Loft conversion at 11 Ferring Marine, Ferring BN12 5PP

Pre-Application Advice

Loft conversion to create a conservatory style addition, additional bedroom at loft level and reconfiguring existing fenestration to the south elevation.

11 Ferring Marine BN12 5PP

PROPOSED
GROUND AND FIRST FLOOR PLAN

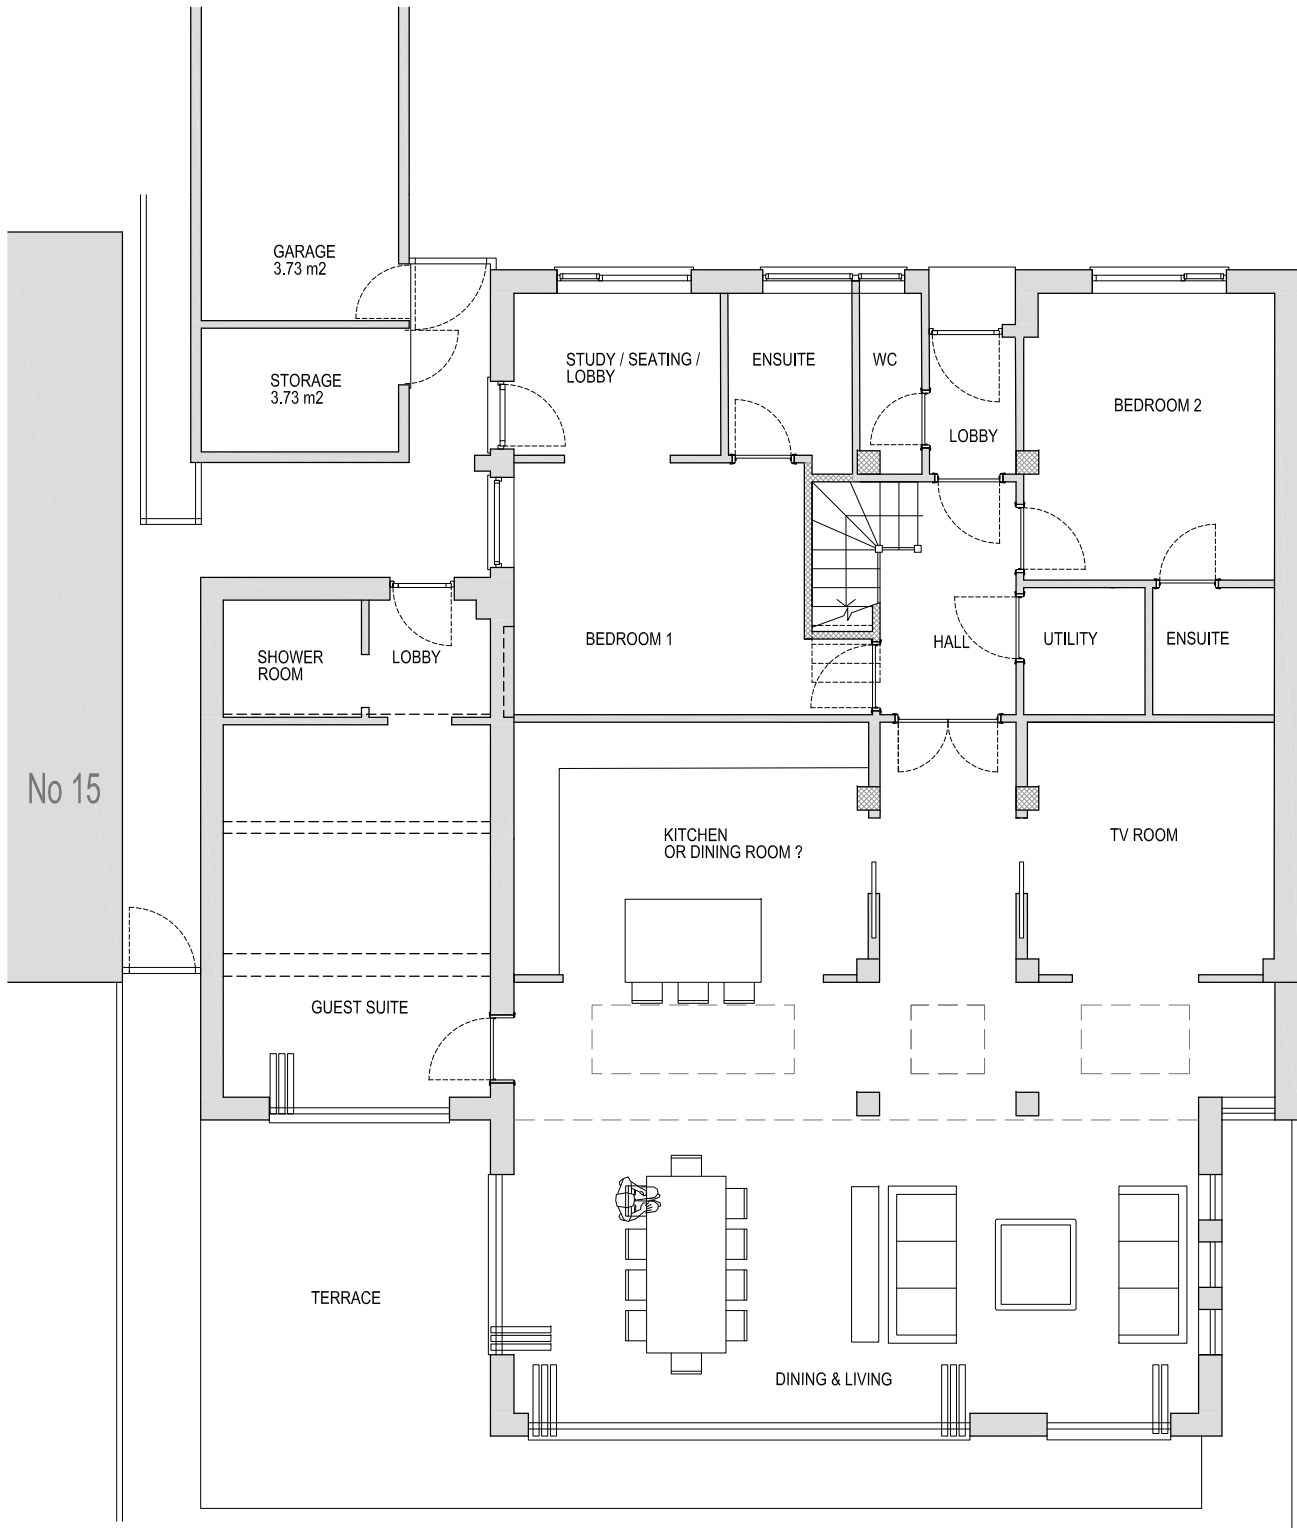
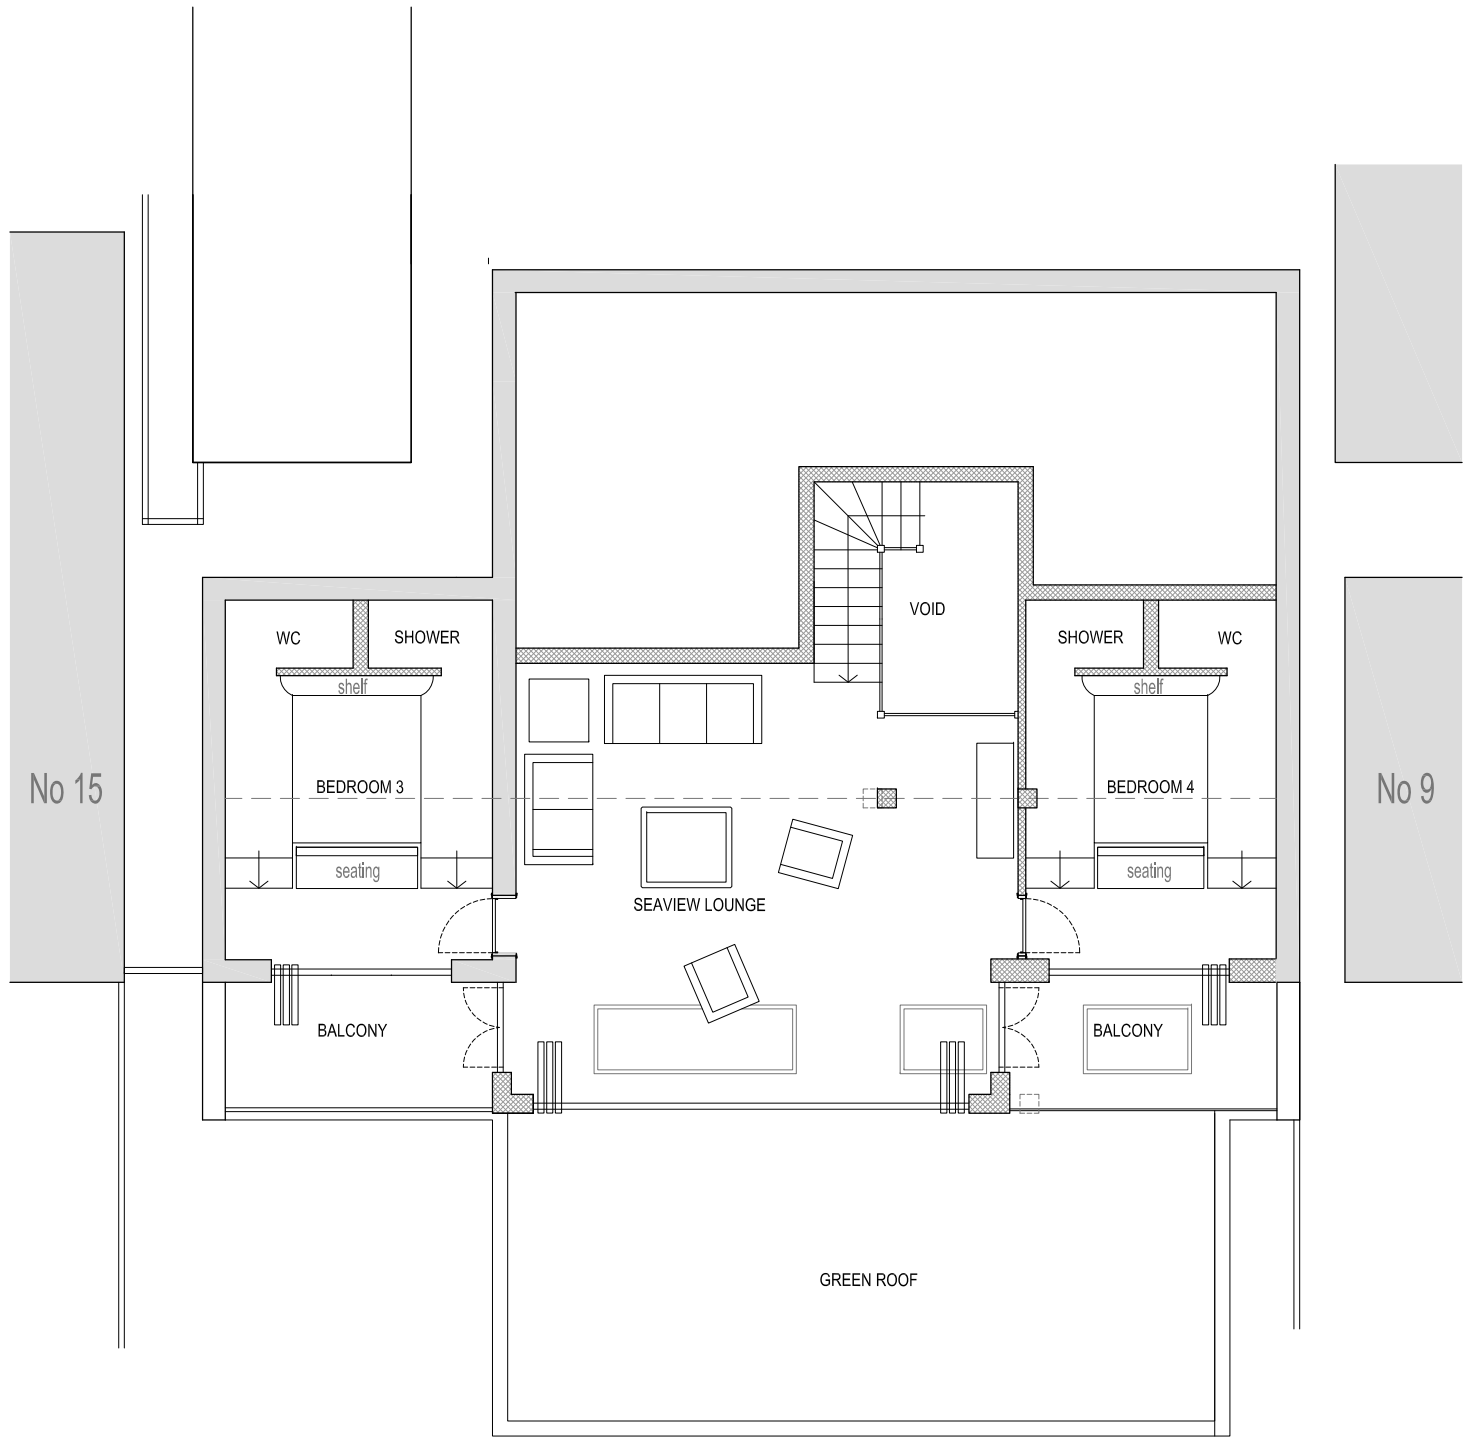
The balconies at first floor level would however be expected to incorporate obscure glazed privacy screens at a minimum of 1.8 metres from the roof slope to the rear elevation to avoid any unnecessary overlooking of neighbouring properties

PROPOSED  
ELEVATIONS AND  
MAIN SECTION

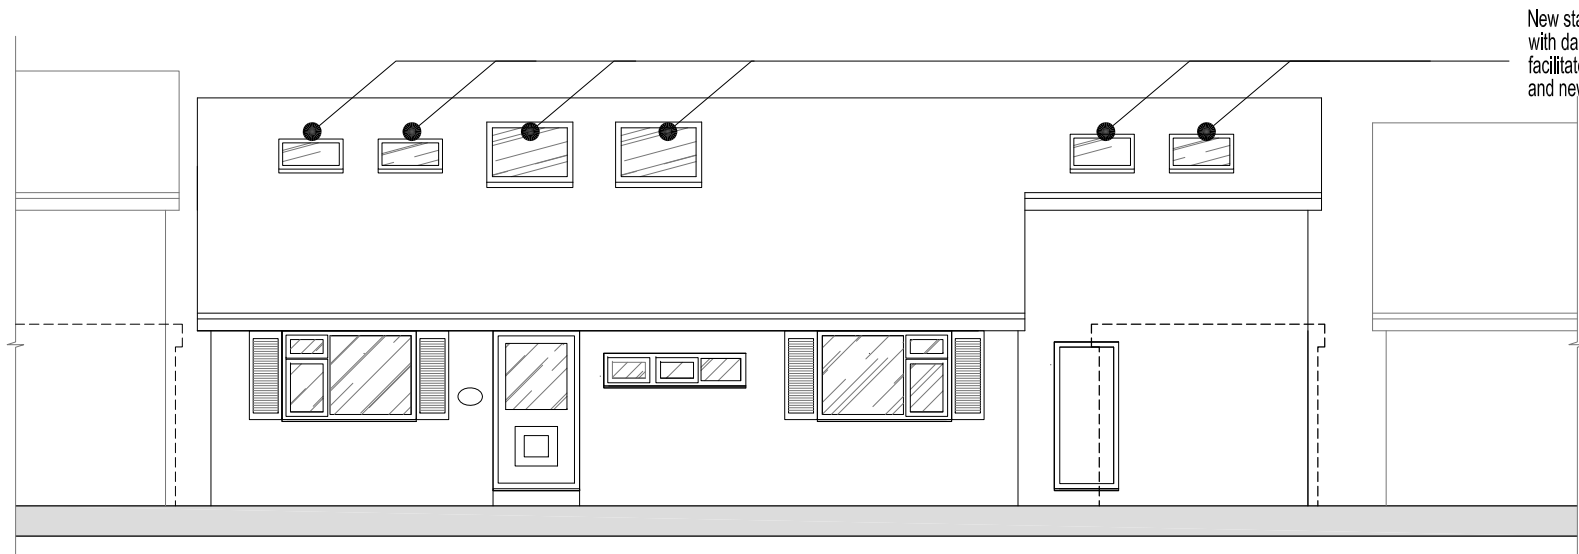
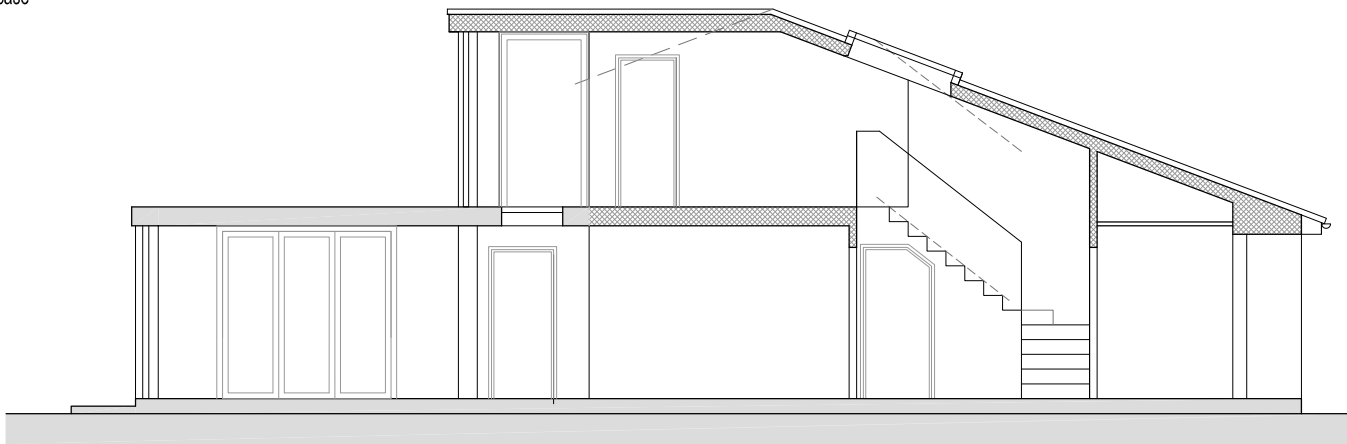
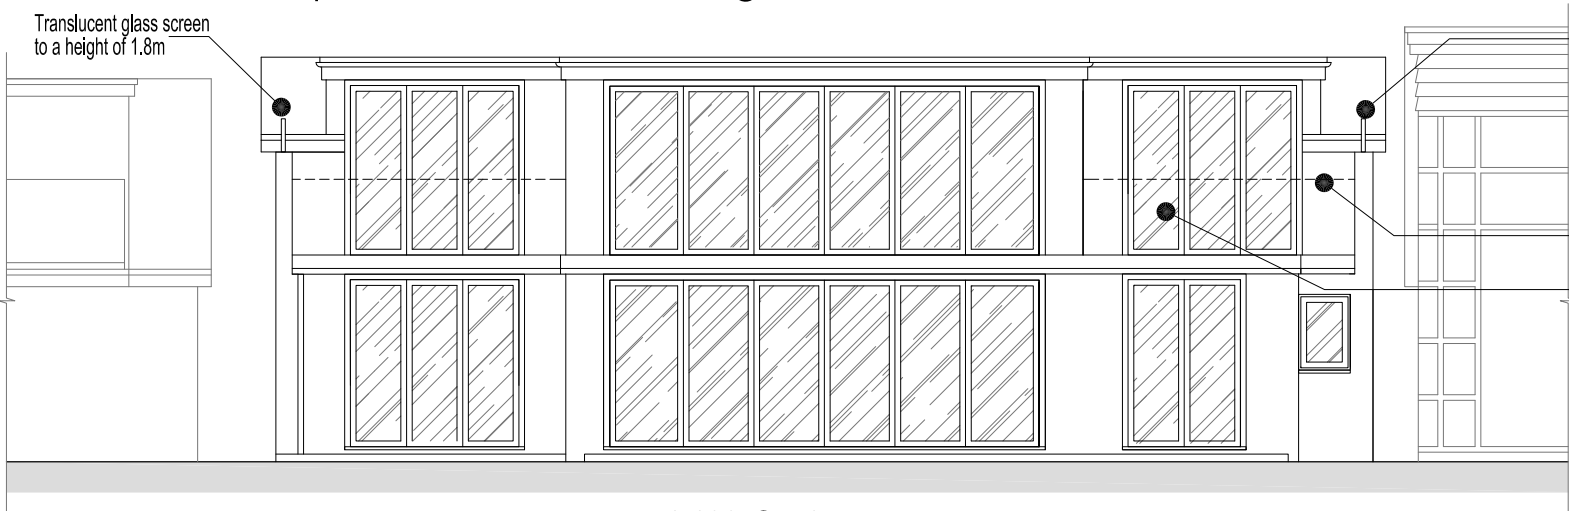
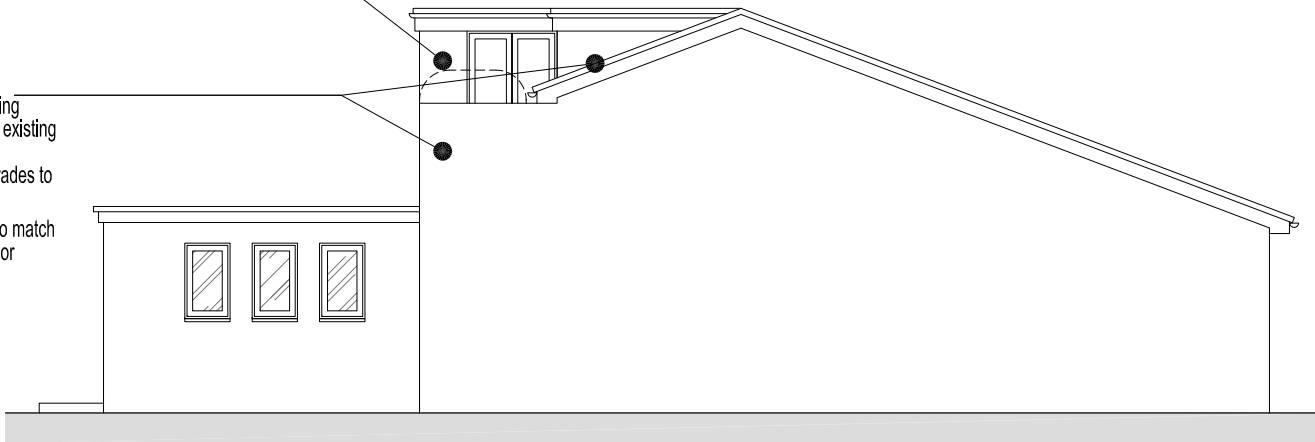
The proposed development of first floor loft extension at the rear of the property has occurred at a number of properties nearby however the difference with this proposal is that the loft extension would rise above the ridge line in the centre of the dwelling introducing a glazed atrium feature to the front elevation. This would introduce an incongruous prominent feature into the street scene which would;

- Fail to visually integrate with and sympathetically relate to the existing dwelling contrary to part a of policy D DM4
- Fail to be visually subservient to the main building contrary to part b. of policy D DM4

It is considered that a raising of the roof line to incorporate the loft extension as in neighbouring properties would be acceptable but a protrusion above that ridge line would be unacceptable.

The proposed glazed roof of the loft extension would project above the height of the main extended ridge height forming a prominent feature on the front elevation of the property which would not be subservient to the main building and would fail to sympathetically relate to and integrate with the building as a whole, adversely impacting upon the character of the area contrary to policies D DM1 and D DM4 of the Arun Local Plan.
